**CITY OF ALBUQUERQUE
PLANNING DEPARTMENT
February 23, 2005
DRB Comments**

PROJECT # 1003973 & 1003974 APPLICATION # 05-00299 & 00300

RE: Tracts 5 & 7, The Trails, Unit 2/2 sketches

DRB CASE NO/PROJECT NO: 1003974

SKETCH PLAT FOR  
**TRACT 5,  
THE TRAILS  
UNIT TWO**  
CITY OF ALBUQUERQUE  
BERNALILLO COUNTY, NEW MEXICO  
FEBRUARY, 2005

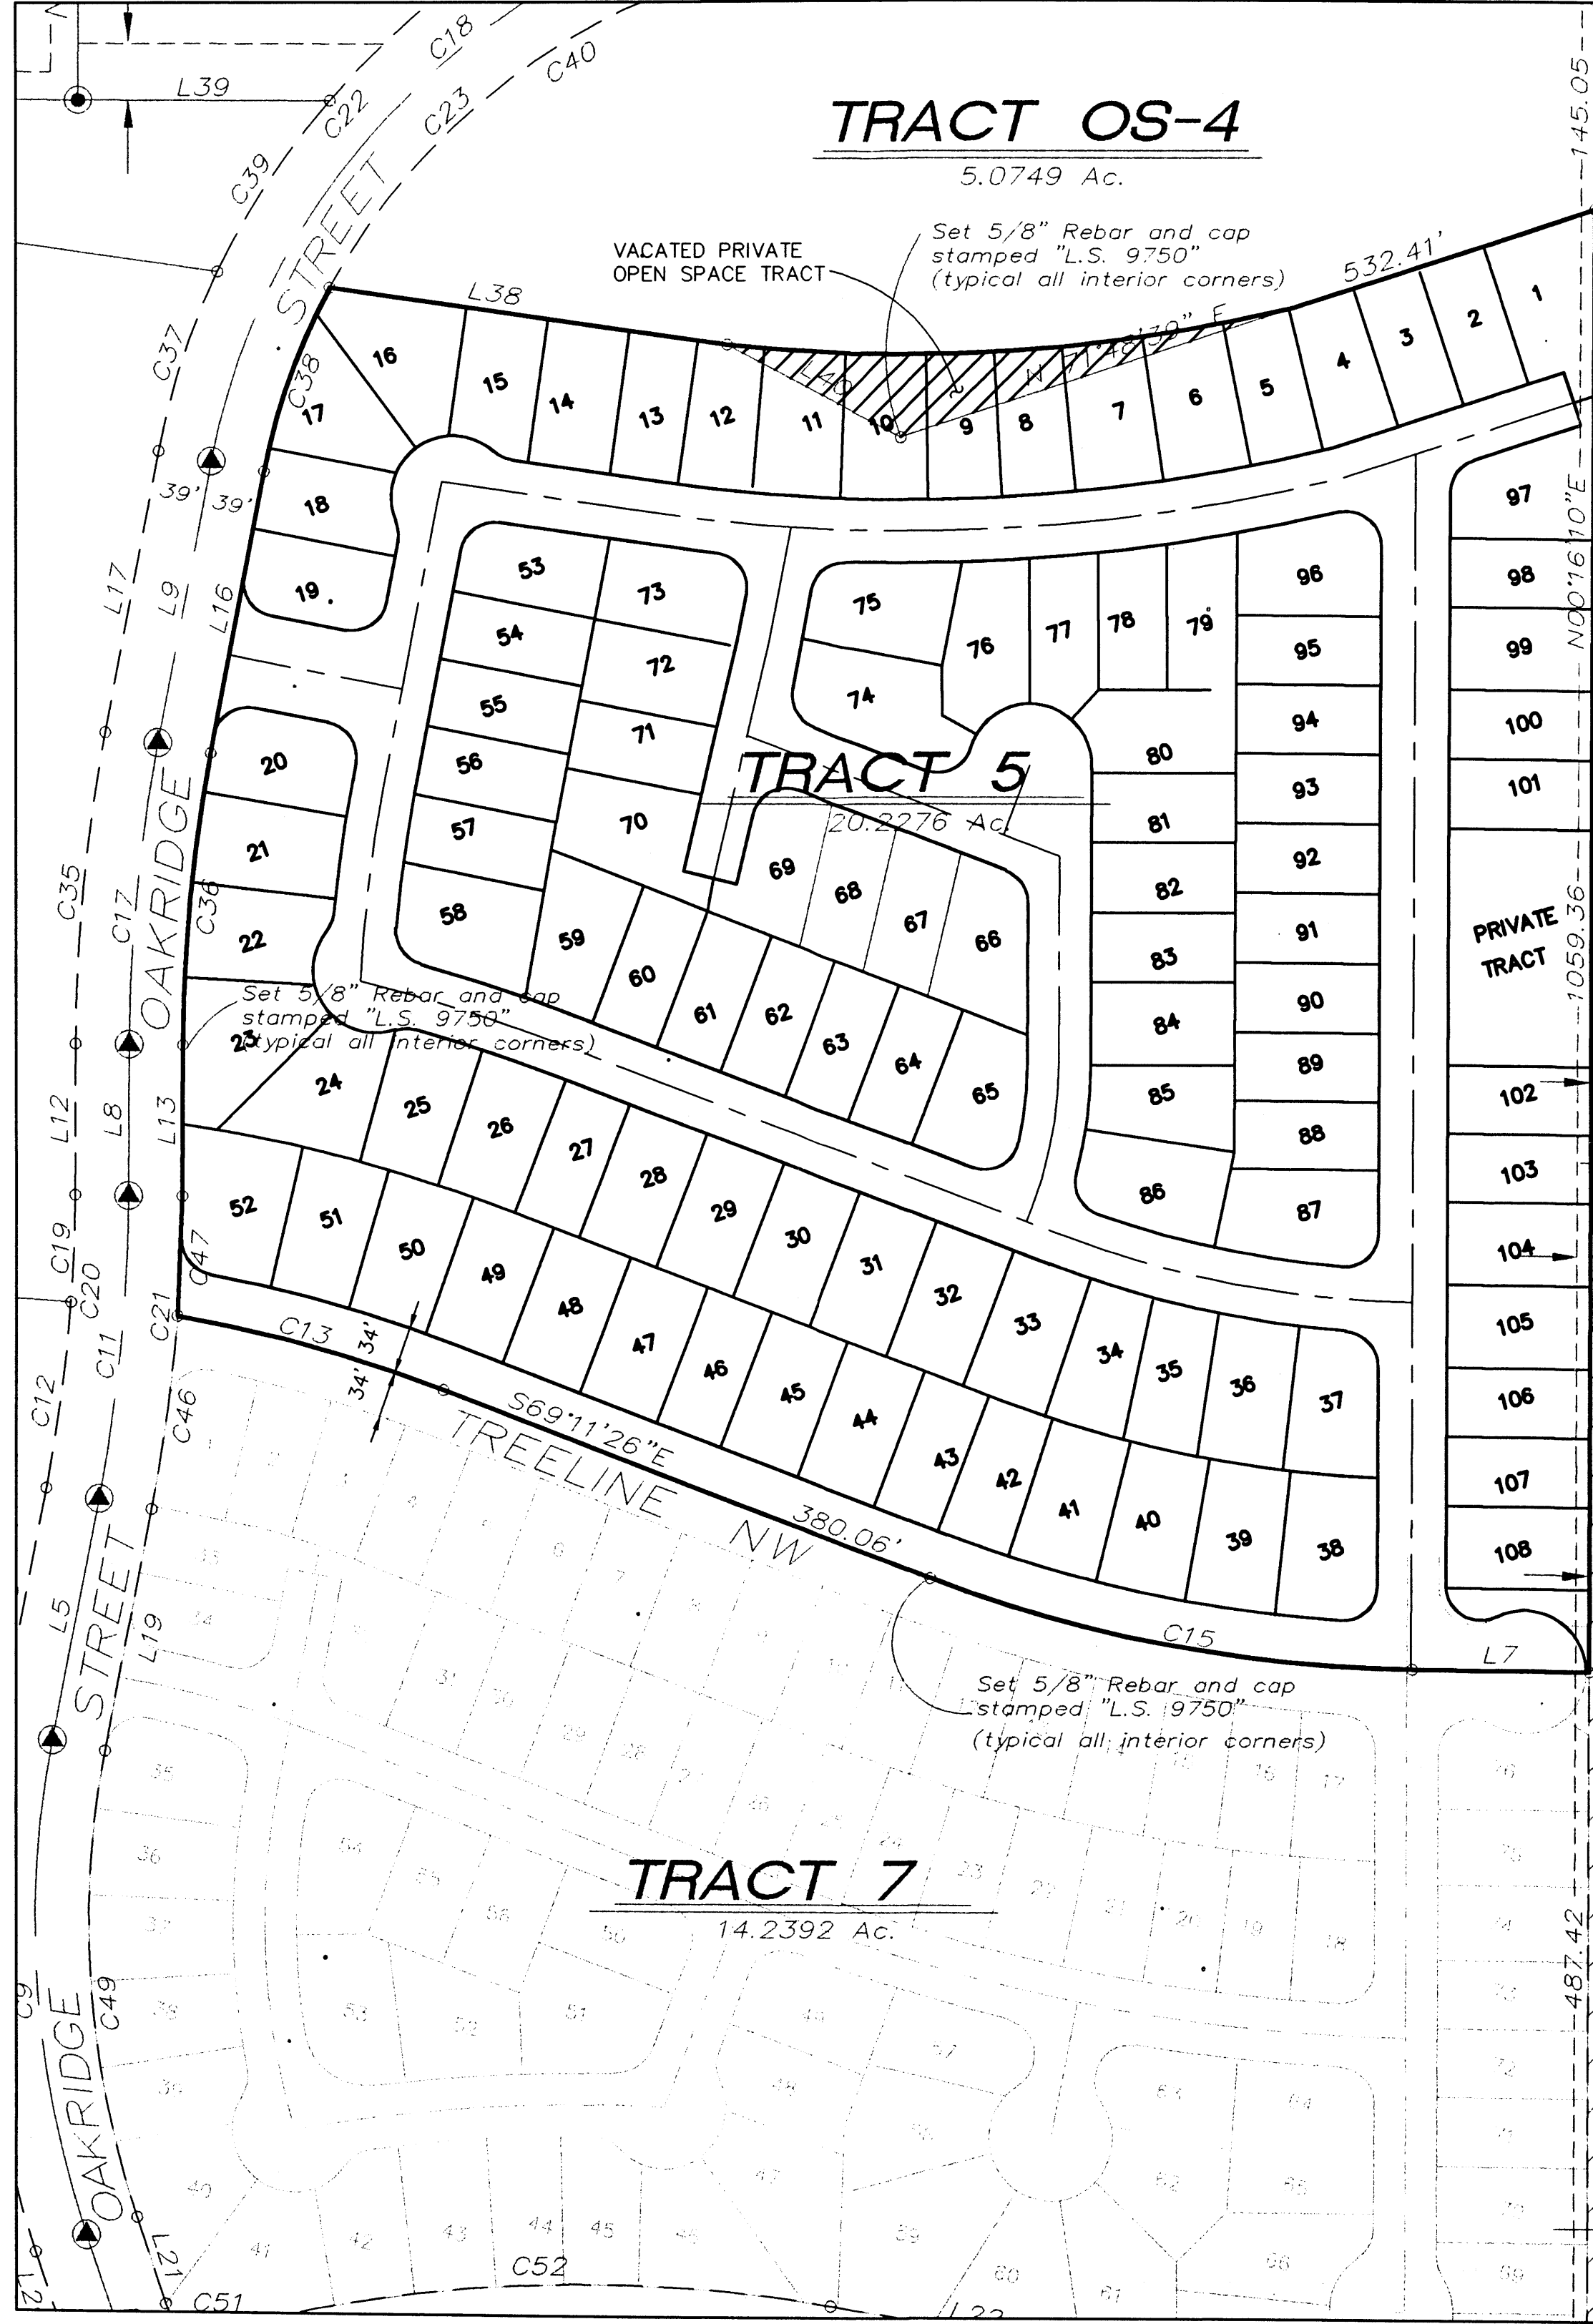
How do these two sketch plats relate to the cap on the number of dwelling units allowed in the Trails prior to the sector development plan approval?

In moratorium area.

An approved drainage report is required for Preliminary Plat approval.
An approved infrastructure list is required for Preliminary Plat approval.
